April 26, 2024

Revise/provide Pond Certification Letter with required statements listed in ECM Section 5.10.6.B:

The permanent stormwater Best Management Practices (BMPs) for The Villas at Claremont Ranch consist of development of a full spectrum extended detention basin located in the northern portion of the subdivision adjacent to Sand Creek. The pond requires 0.139 acre-feet of water quality capture volume and a total (100-YR) volume of 0.760 acre-ft. Catamount Engineering has reviewed the as-built survey of pond, and outlet structure prepared by M&S Land Surveys and performed field measurements of structures. The as-built drawings indicated that the overall pond volume, the pond inlet, and outlet structures were constructed in general conformance with the approved design.

PRIVATE EXTENDED DETENTION BASIN
SCALE: 1" = 20'

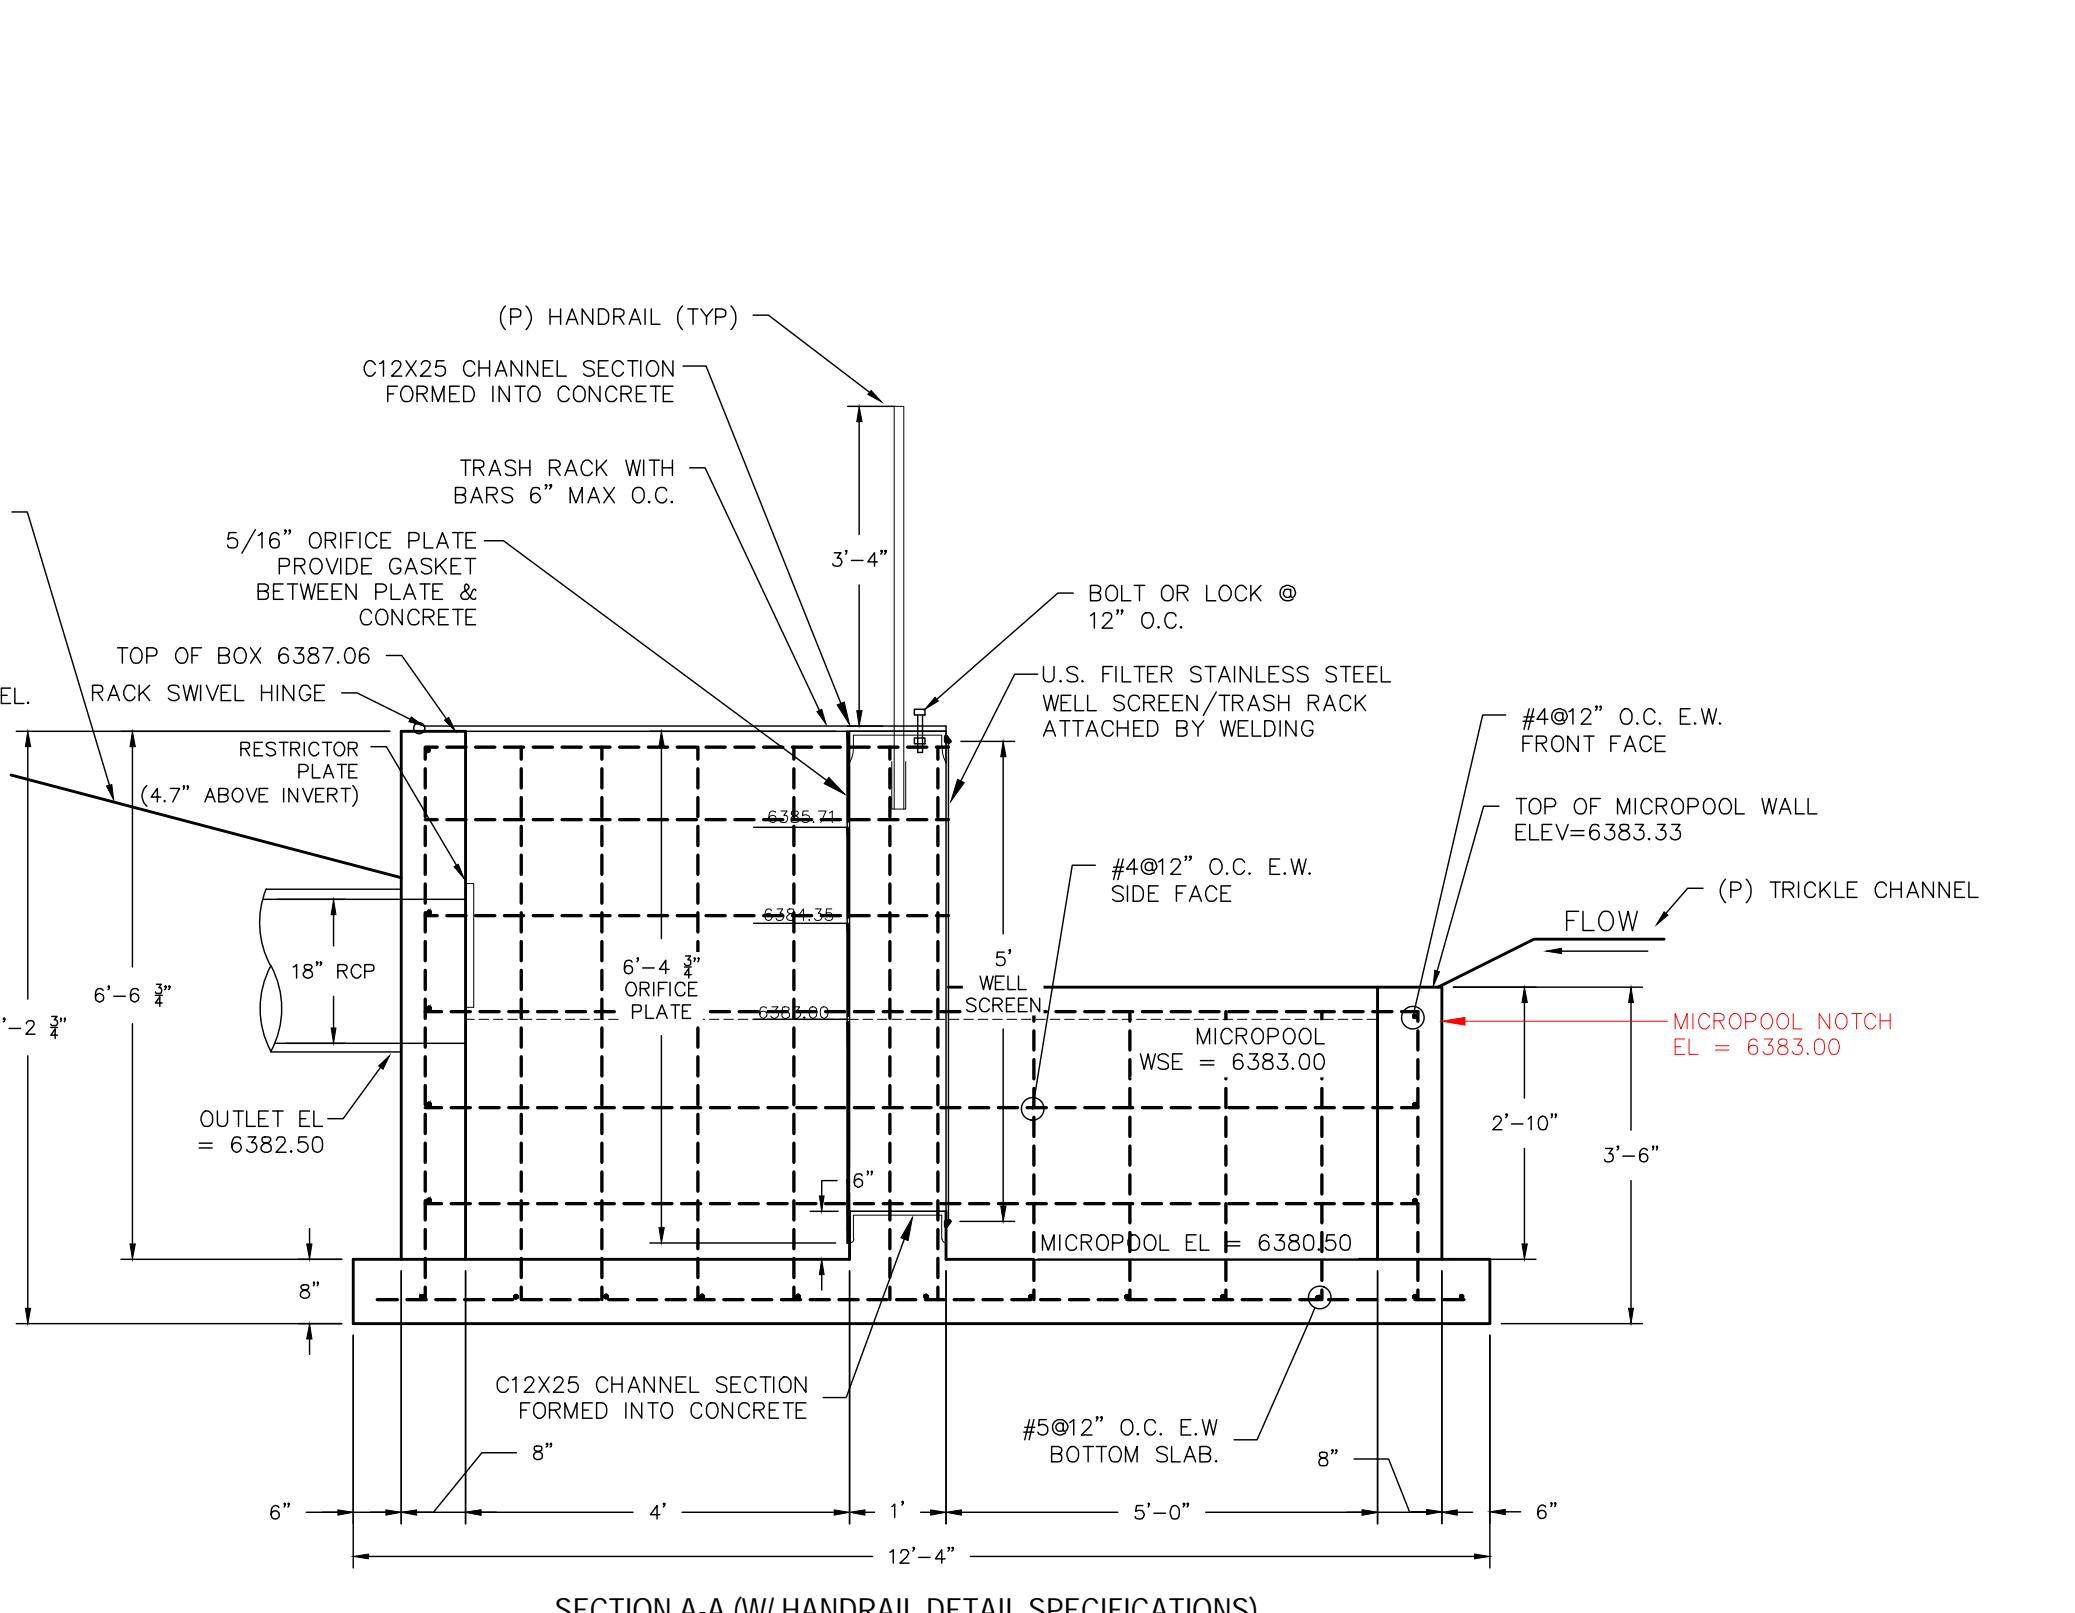
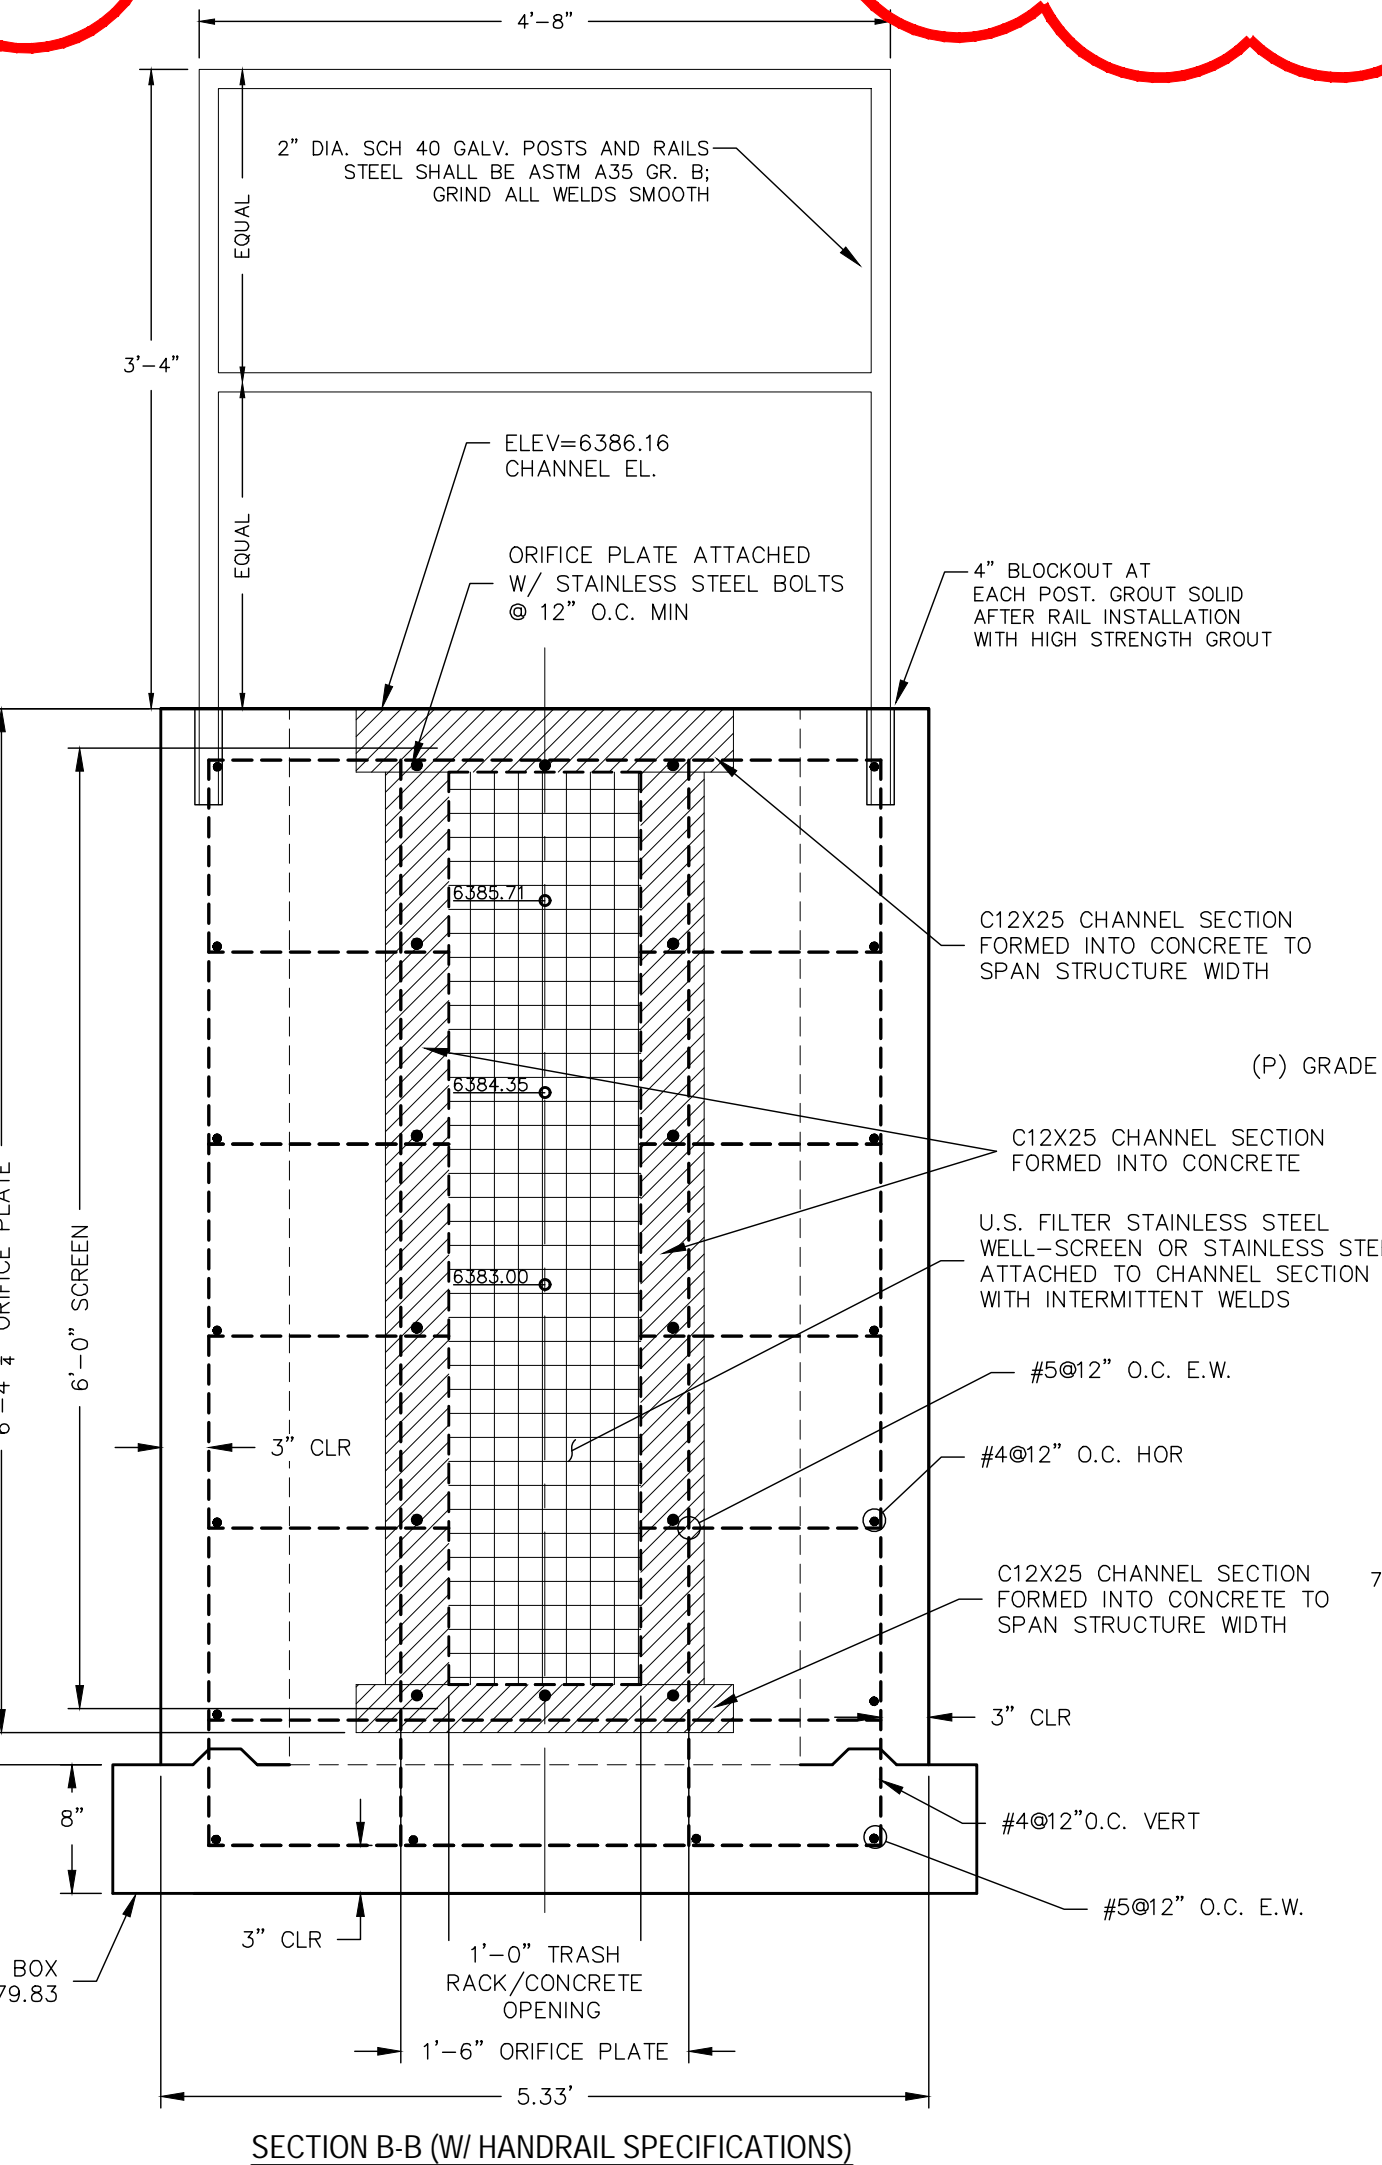
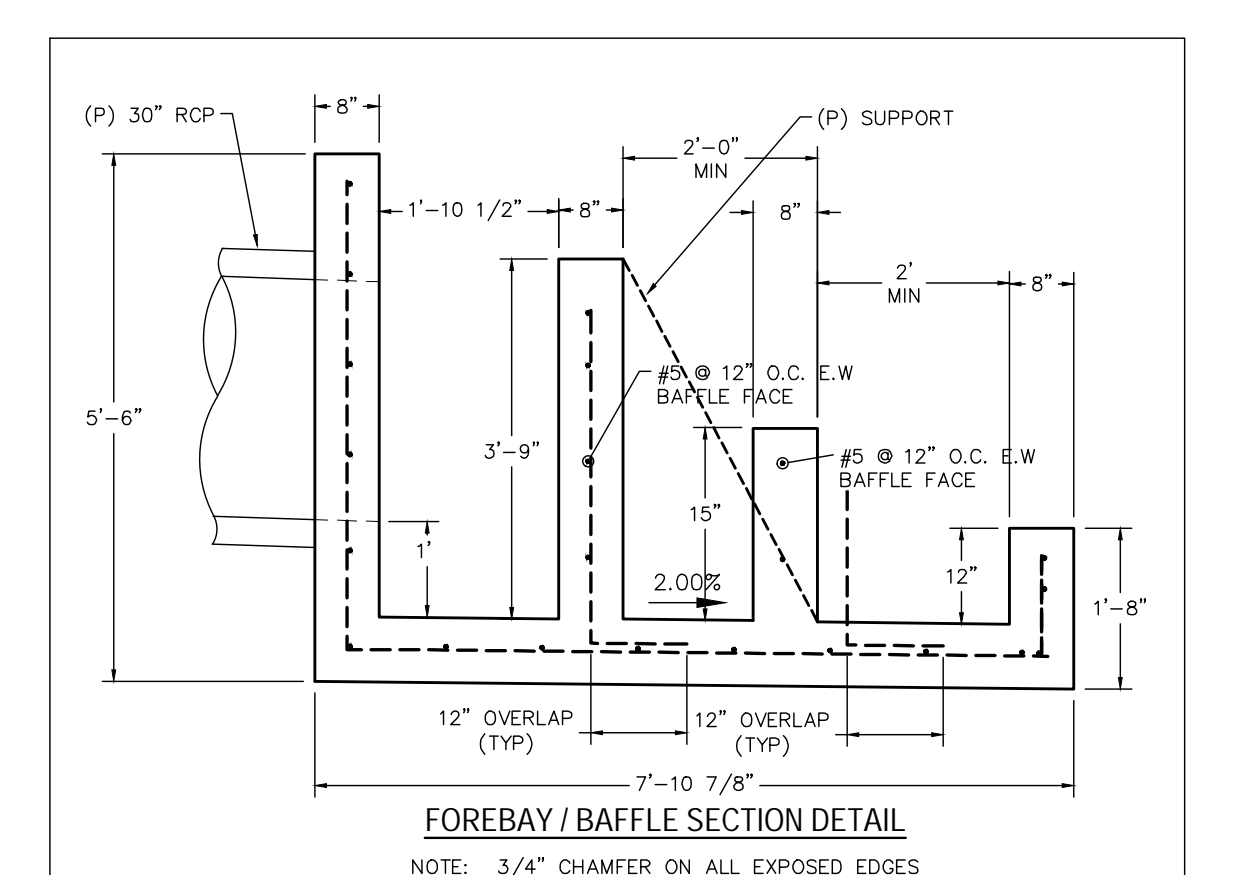
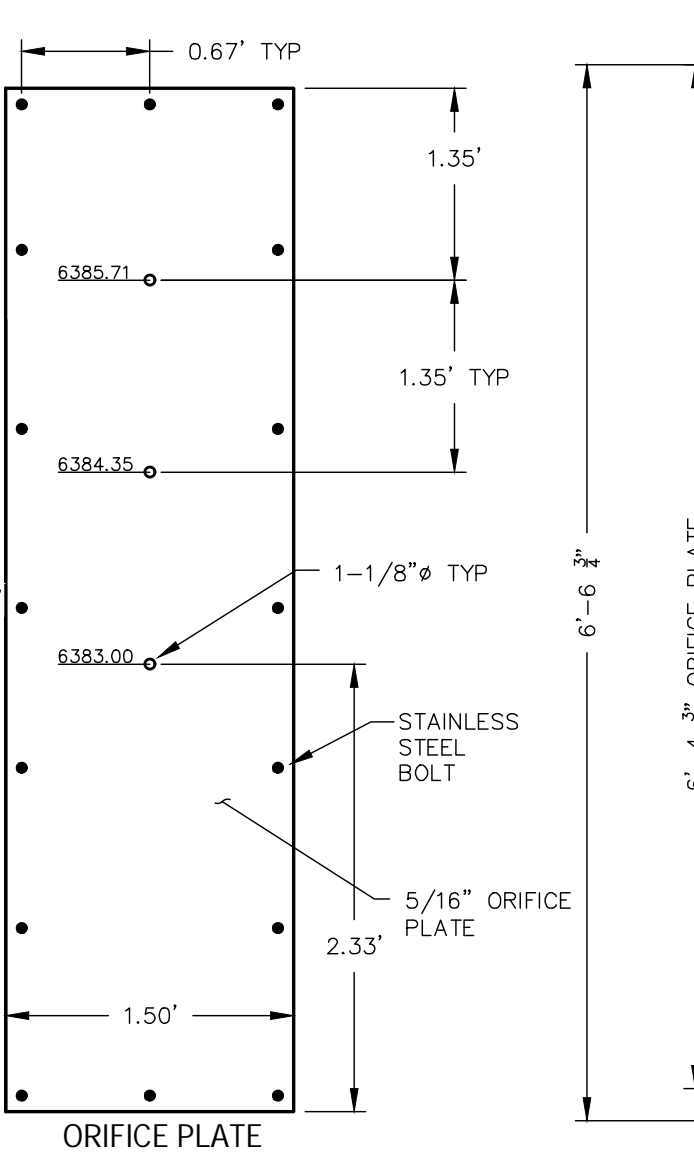
Provide this survey topo and data on the as-built CDs.

- The approved plans indicated an emergency overflow width of 20'. The emergency overflow was constructed 16' wide with required 4:1 side slopes. The 16' spillway width raises the water surface of the fully plugged overflow condition by 0.04' and adequate berm height exists to maintain the 1.0' freeboard required. The increase in unit flow will not change sizing of required buried riprap.

- The trickle channel was revised to a 1.0' width x 6" deep trapezoidal channel vs. the inverted crown design in the original plan. The original alignment was utilized and the trapezoidal channel was installed at a longitudinal slope of 0.5%. The trickle channel enters the micropool below the lip of the structure (initial surcharge volume) but above the micropool outfall depth.

- The pond outfall location was revised to eliminate crossing of CSU water transmission mains. The outfall maintains configuration of initial design outfalling 1.0' above the toe of the channel bank to a riprap energy dissipator that maintains positive grade in excess of 2.0% to the top of the defined low flow channel in the center of the creek.

Please update the MHFD-Detention Spreadsheet with the updated as-built information (pond elevations, spillway length, orifice hole elevations, etc.) to confirm that the pond is functioning as intended. The original Spreadsheet is included with the approved Drainage Report. The updated Spreadsheet should be attached to the Pond Certification Letter.
